SafeWork NSW

22 December 2021

COCKLE BAY WHARF MIXED USE DEVELOPMENT (SSD-9978934)

-  Denotes Existing Structure
-  Denotes Proposed Land Bridge Structure
-  Denotes Demolished Structure

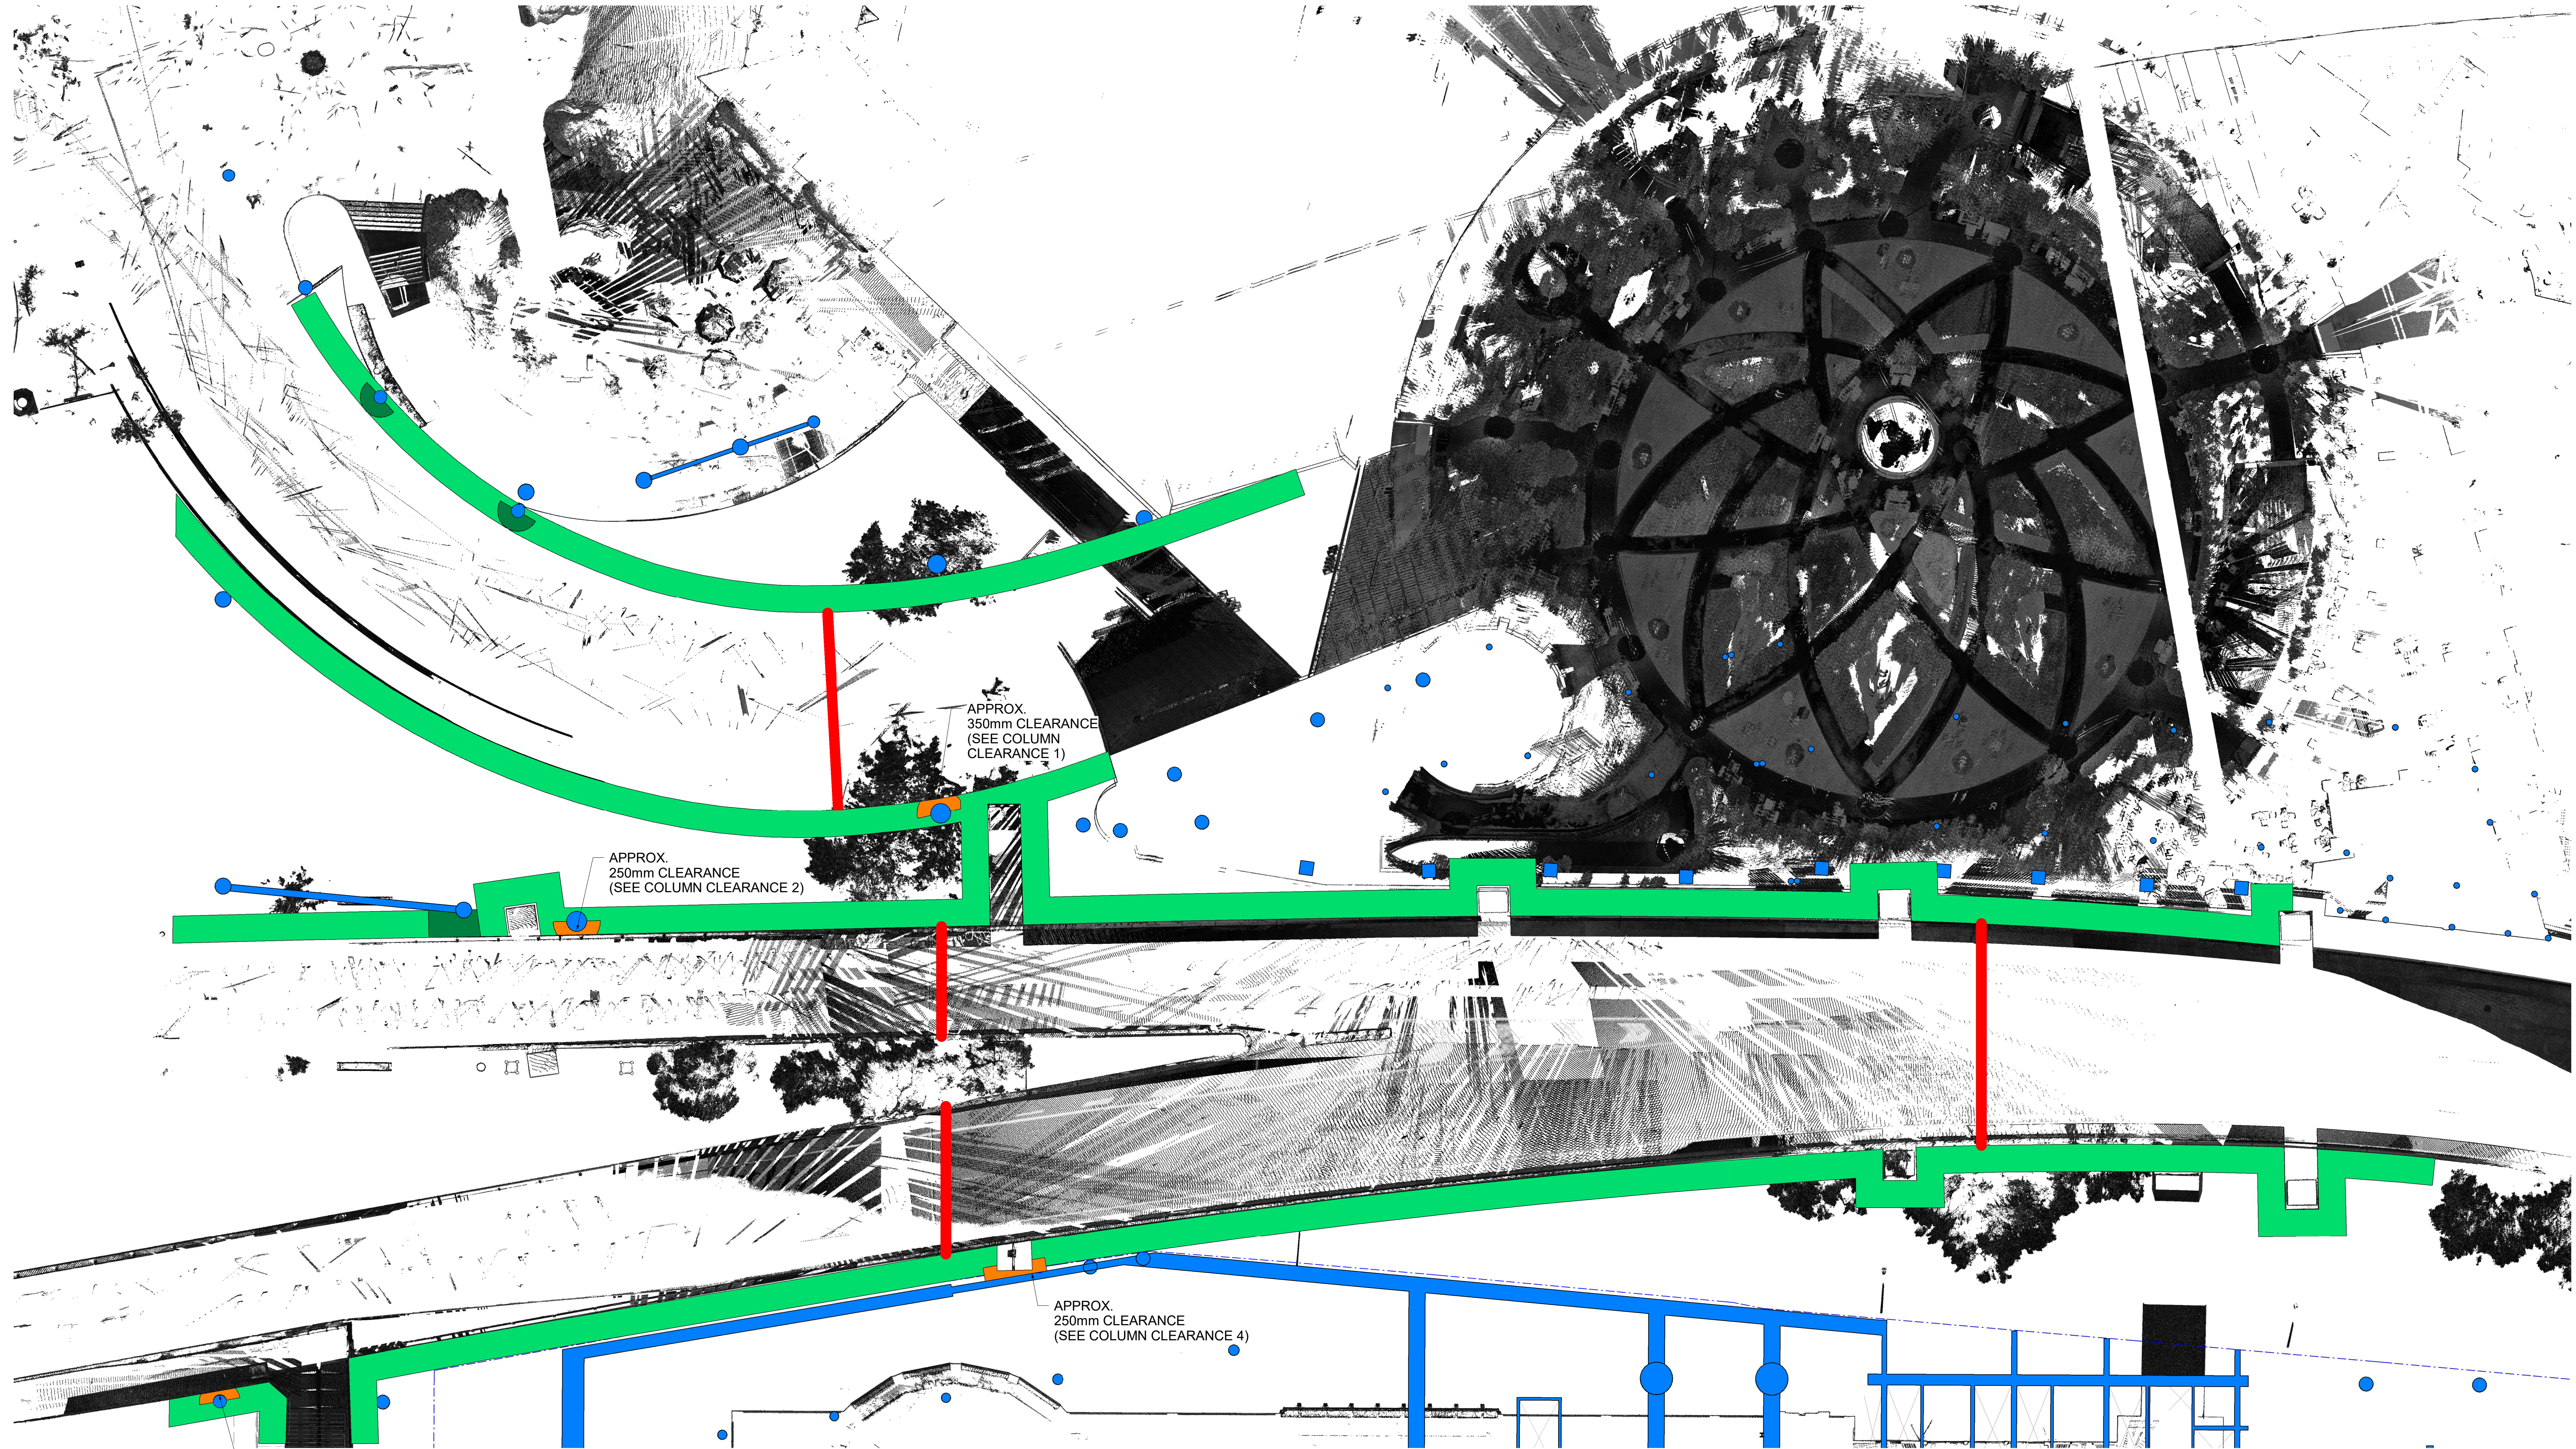
Subsequent stakeholder consultation that has been undertaken by the Applicant has been based on the premise that the enclosure of the space beneath the proposed land bridge

development does not constitute a tunnel on the premise, that the space 'is not substantially enclosed' and as such the requirements of AS 4825-2011 *Tunnel fire safety* are not required to be addressed.

A tunnel is considered within the context of this submission to be as defined within AS 4825-2011 *Tunnel fire safety* as "a substantially enclosed roadway or track-way greater than 80 metres in length." AS 4825-2011 further states that "what constitutes a tunnel depends on the likelihood of development of untenable conditions. If the degree of cover is less than 75%, the accumulation of smoke is unlikely." Given that the existing WD carriageways would be bounded by the proposed land bridge development (that is, enclosed by wall and roof structures) and that there is a resulting potential for untenable conditions, the EPA, SafeWork, and FRNSW consider this space to constitute a tunnel.

If consent is granted for the project, that DPIE consider the AS 4825-2011 definition of a tunnel in the drafting of conditions relevant to safety such as fire and life safety systems and measures that are typically afforded to modern road tunnels.
